Colston Budd Rogers & Kafes Pty Ltd

20 August, 2021

**RE: PROPOSED WAREHOUSE AND CUSTOMER FULFILMENT CENTRE,
74 EDINBURGH ROAD, MARRICKVILLE (SSD-10468)**

20.0m ARTICULATED  
VEHICLE SWEEP PATHS

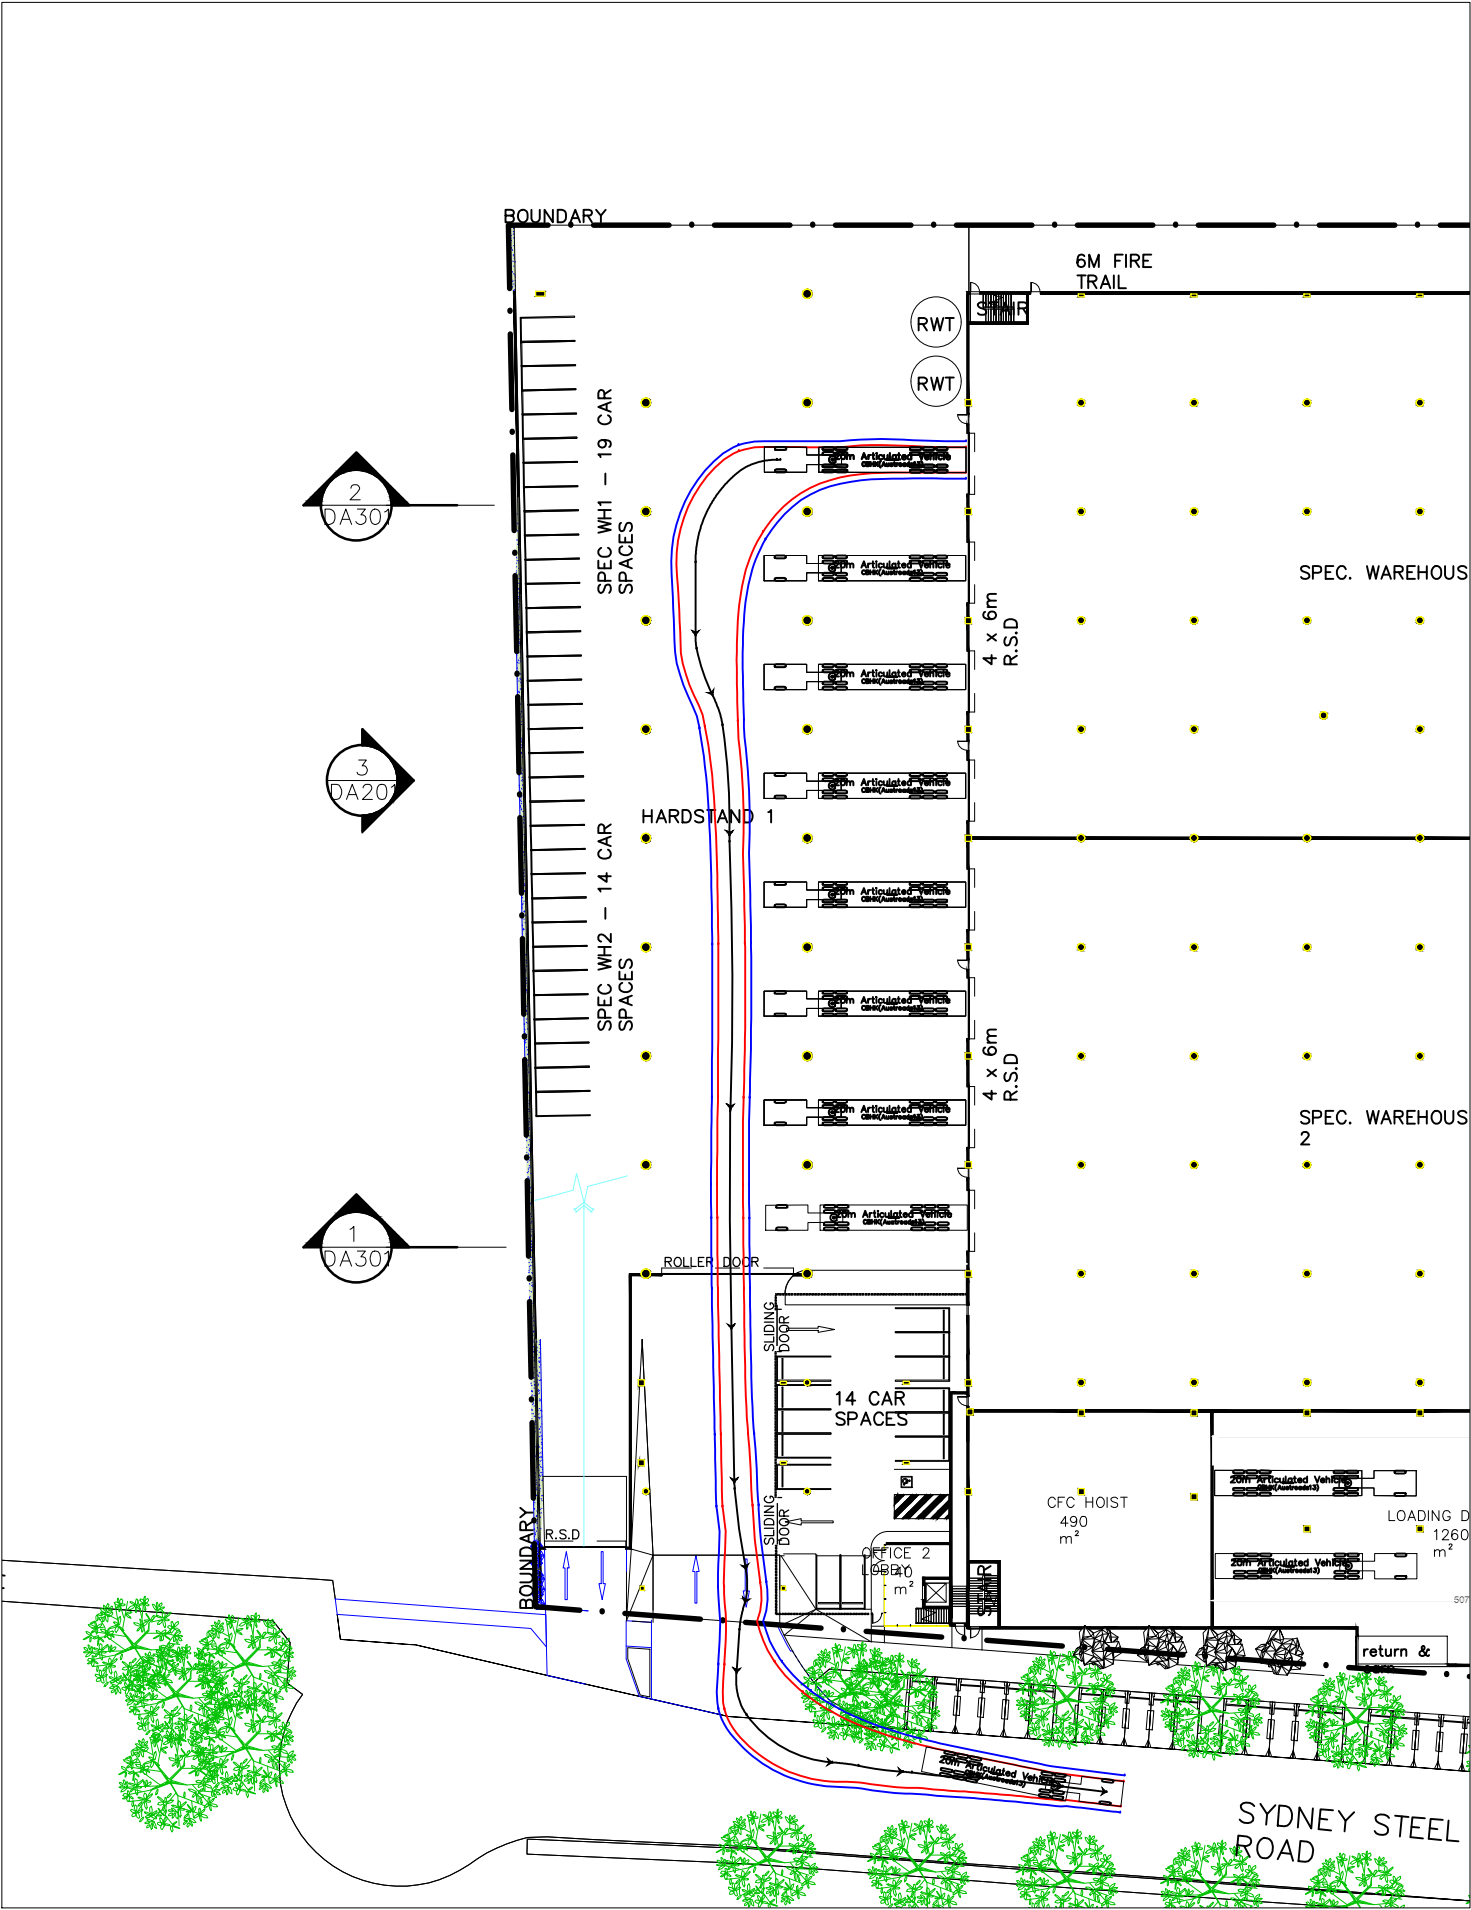
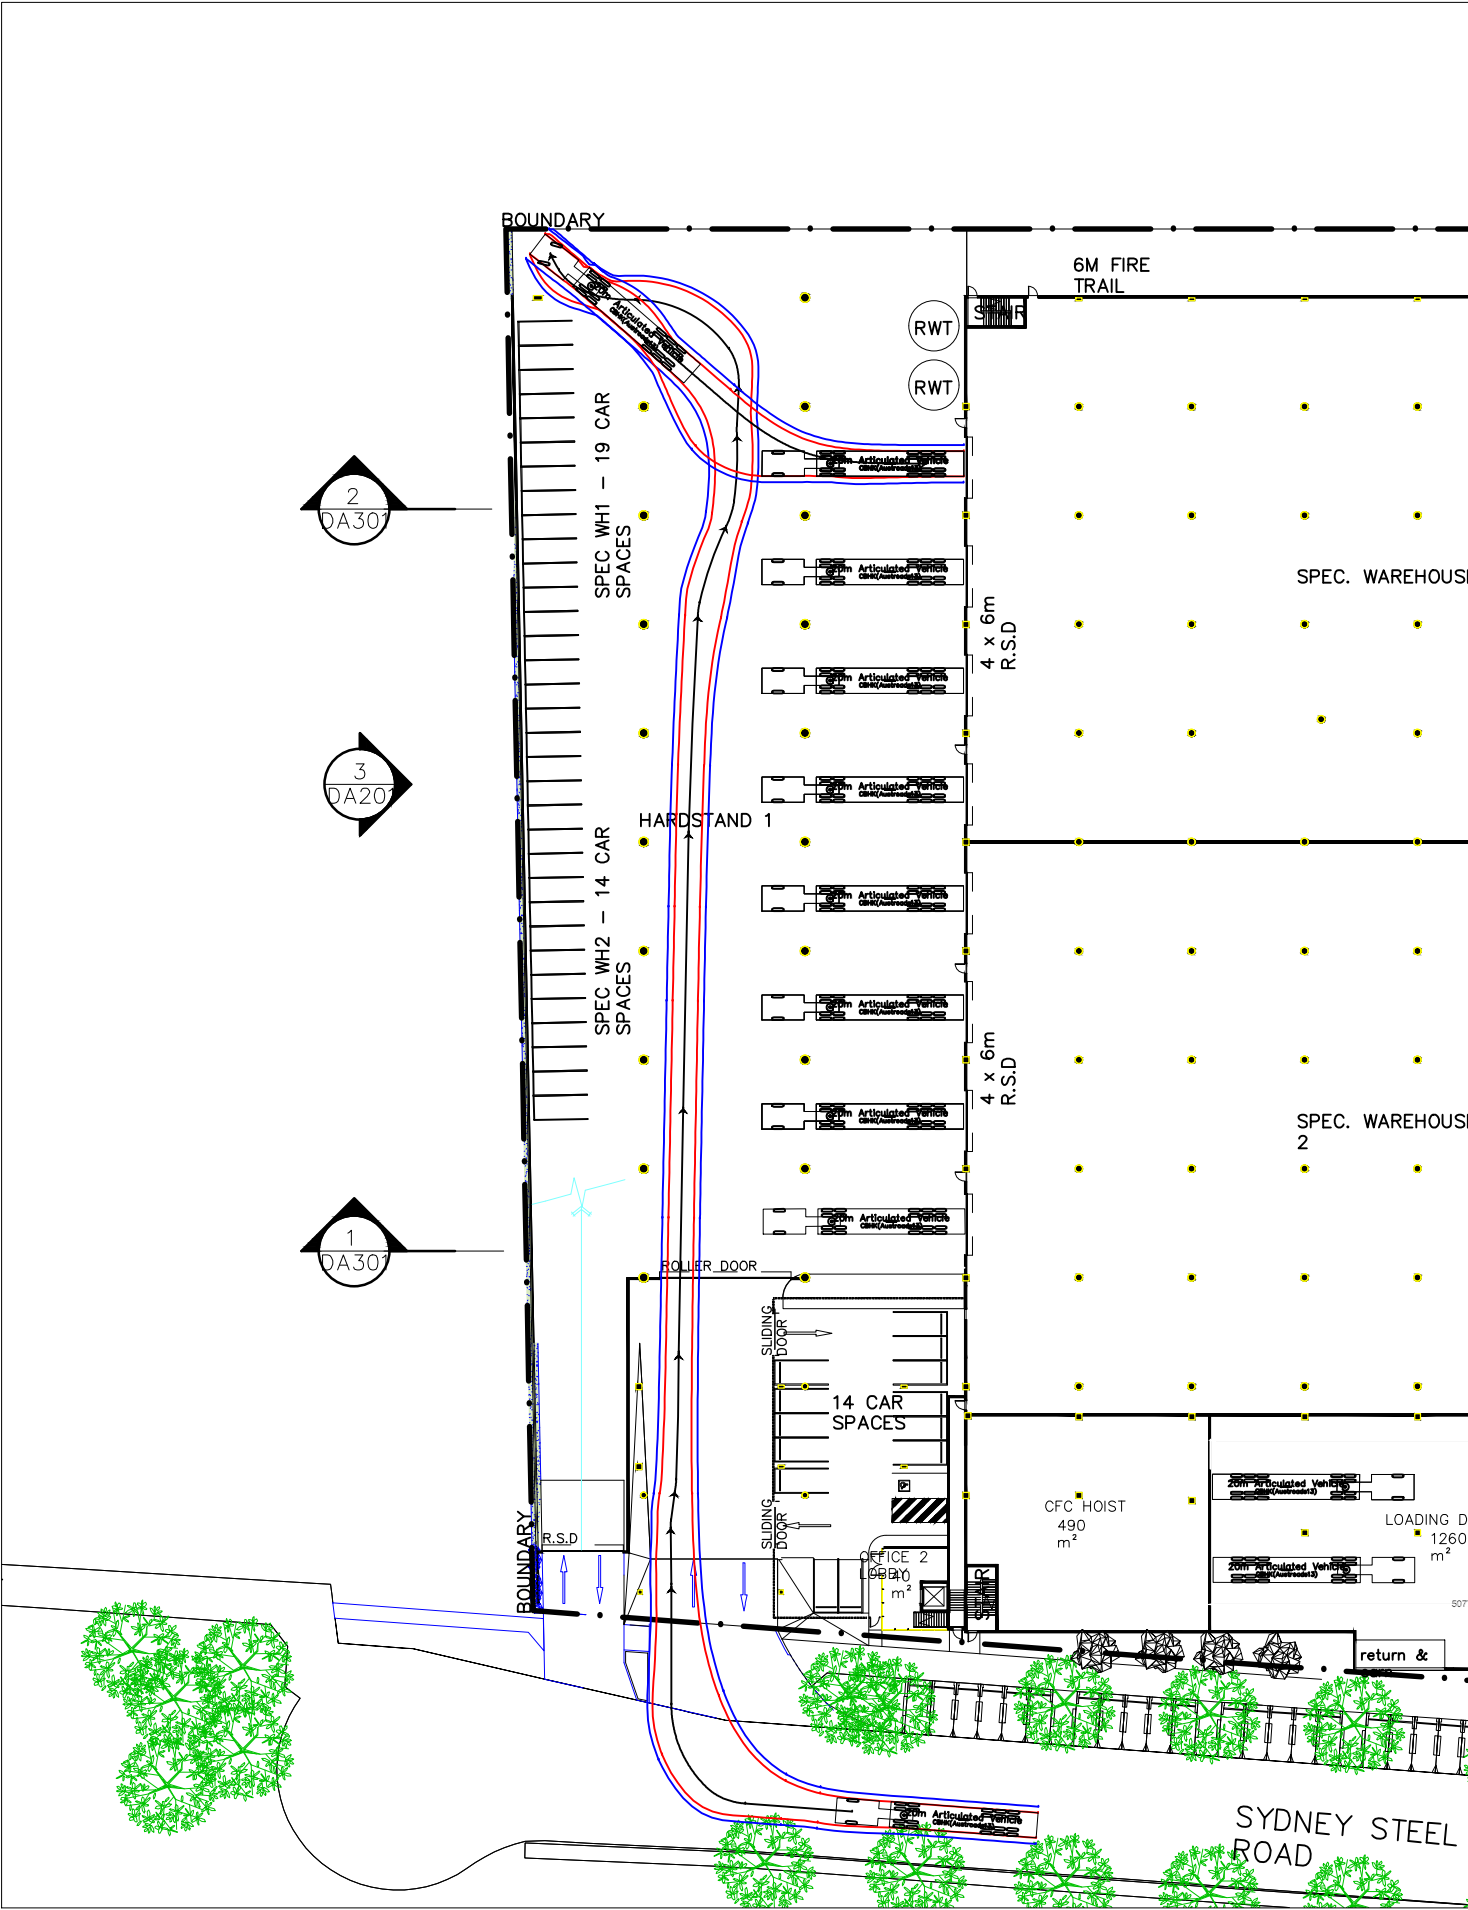
TfNSW has reviewed the internal swept paths for the site and notes that the semi-trailer movement (Sheet 9 in the TIA) is only illustrating the end docking space being utilised. For the other seven loading dock spaces to be utilised, TfNSW believes that the movements may encroach on the car parking spaces.

The proponent is to review the swept path of all semi-trailer movements to ensure that the vehicles can operate without impacting the proposed car parking areas.

13. The western-most dock was included as this is the most constrained in terms of manoeuvring area. Semi-trailers will be able to access all docks, as shown in the attached Figure 1.

PRELIMINARY PLAN

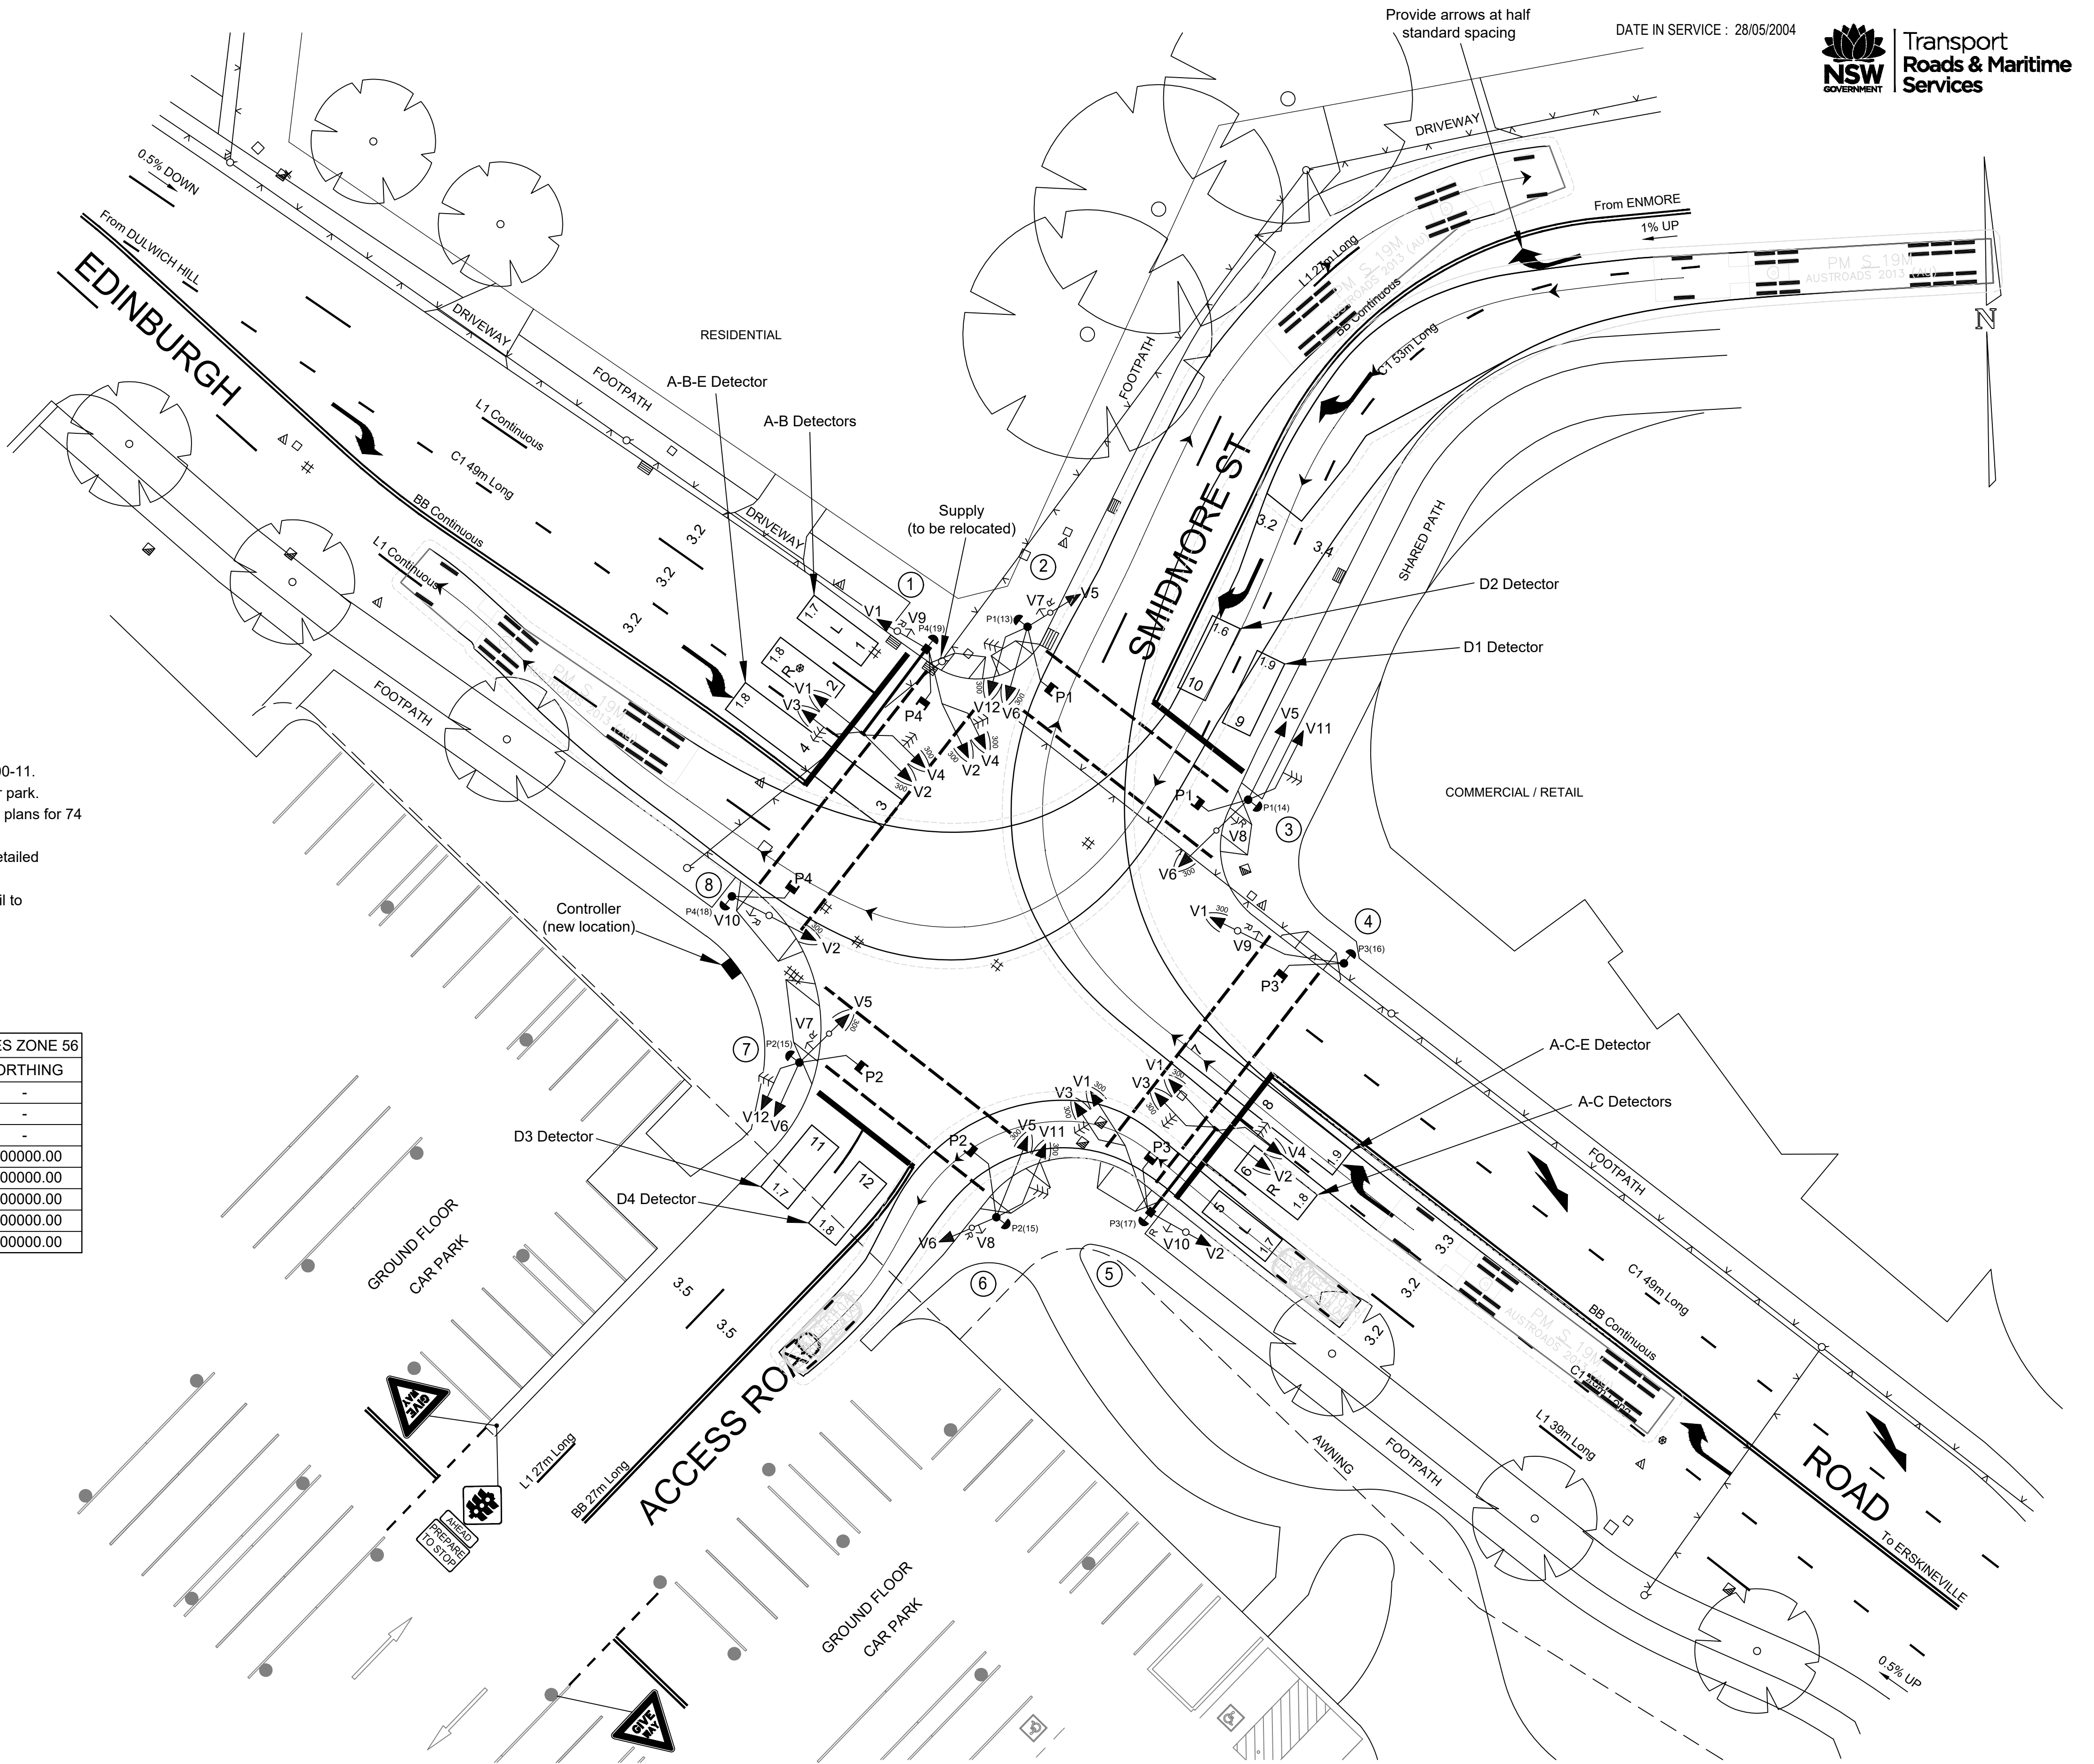
- *In regards to the TCS design plan file name “VV3769_XA_R3” – the right turn bay arrangement will cause significant confusion to motorists and is a major safety concern particularly when a vehicle wants to turn right into the driveway and the vehicles behind wants to turn at the signals. This would cause frequent lane changing with a very short distance, resulting in potential increase in side swipes and rear ends. This proposed right turn bay layout would require two separate right turn bays and within a short distance of less than 50m, it is not possible and is considered unsafe and extremely inefficient.*

- *Layout shows 65m kerb side lane on eastern approach of Edinburgh Rd. Proposed TCS design plan shows approx.. 40m. – Could you please check TCS 3769 bay lengths. It appears they are the wrong way around.*

- *Layout shows 65m on departure side of Edinburgh Rd (eastern leg). Proposed TCS design shows 50m on departure side – Could you please check TCS 3769 bay lengths. It appears they are the wrong way around.*

39. This matter relates to whether or not a median is provided in Edinburgh Road which is addressed above in paragraph 27.
- *As previously advised, TfNSW is concerned regarding the complexity of the proposed signalised intersection to include additional phases that would result in queues extending back towards Edinburgh Road / Sydney Steel Road. As such, TfNSW the proposed right turn movement from the west is to be prohibited to mitigate impacts on the surrounding road network and the site would be able to access from the western approach via a roundabout past the site.*

45. The SIDRA modelling includes these amendments.
